**RE: WASTE METAL RECOVERY, PROCESSING AND RECYCLING
FACILITY EXPANSION- EPA RESPONSE TO SUBMISSIONS**

**Refusal to grant General Terms of Approval - Additional information required in EIS
Kings Park Waste Metal Recovery, Processing and Recycling Facility (SSD-5041)
23-43 and 45 Tattersall Road, Blacktown**

Figure 4.4 Location of the point and volume sources modelled

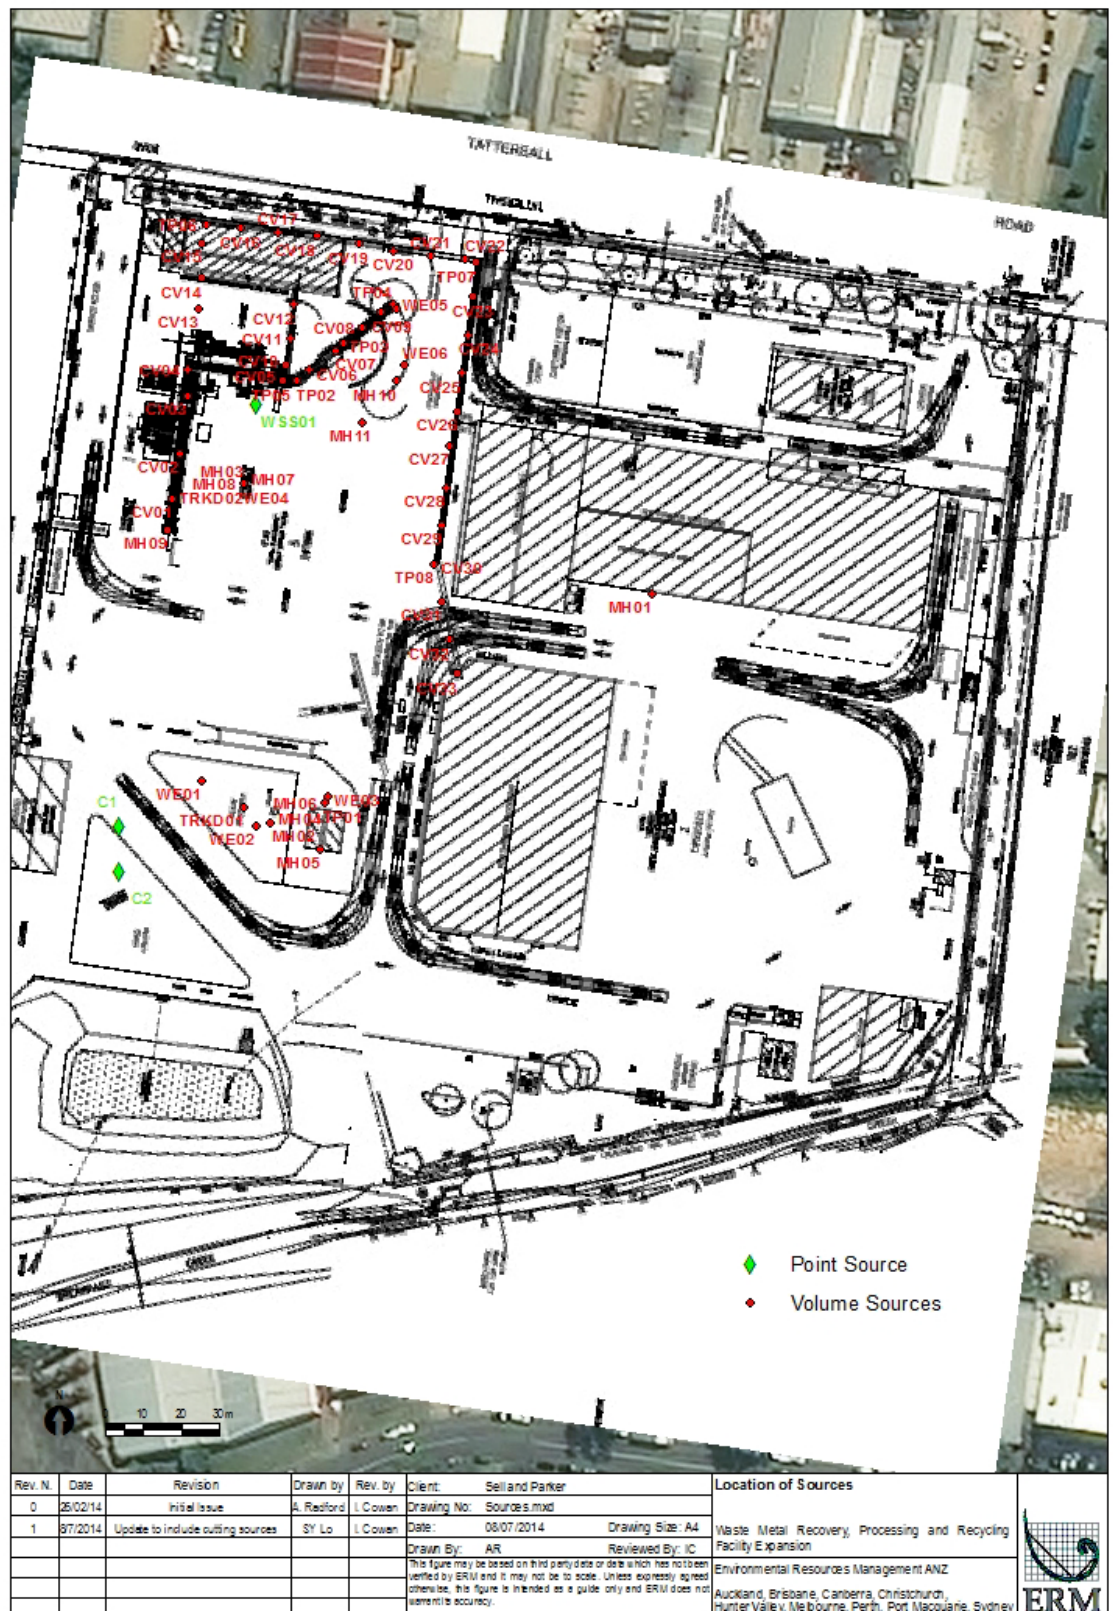
Issue: It is uncertain whether the location of the hammermill where odour monitoring was undertaken is the same as the wet scrubber stack in the modelling. Therefore, the wet scrubber stack specifications for volumetric flow rate and particulate emission concentration used in the modelling may not be appropriate.

ERM Response: The air quality modelling has been updated with the Wet Scrubber reclassified as a volume source and placed in the correct location which is adjacent to the Hammermill control room.

Considering the photographs of the wet scrubber during odour sampling, the wet scrubber on the hammermill vents into a cavity area of the hammermill before rising due to thermal buoyancy to the atmosphere. Consequently, it was considered on re-review of these photographs that a volume source more properly described this source.

EPA Response: A maximum dust concentration of 20 mg/m³ and volumetric flowrate of 20,000 Nm³/h from the hammermill was modelled. The revised modelling of the hammermill in the corrected location is considered to be more representative of the hammermill emissions.
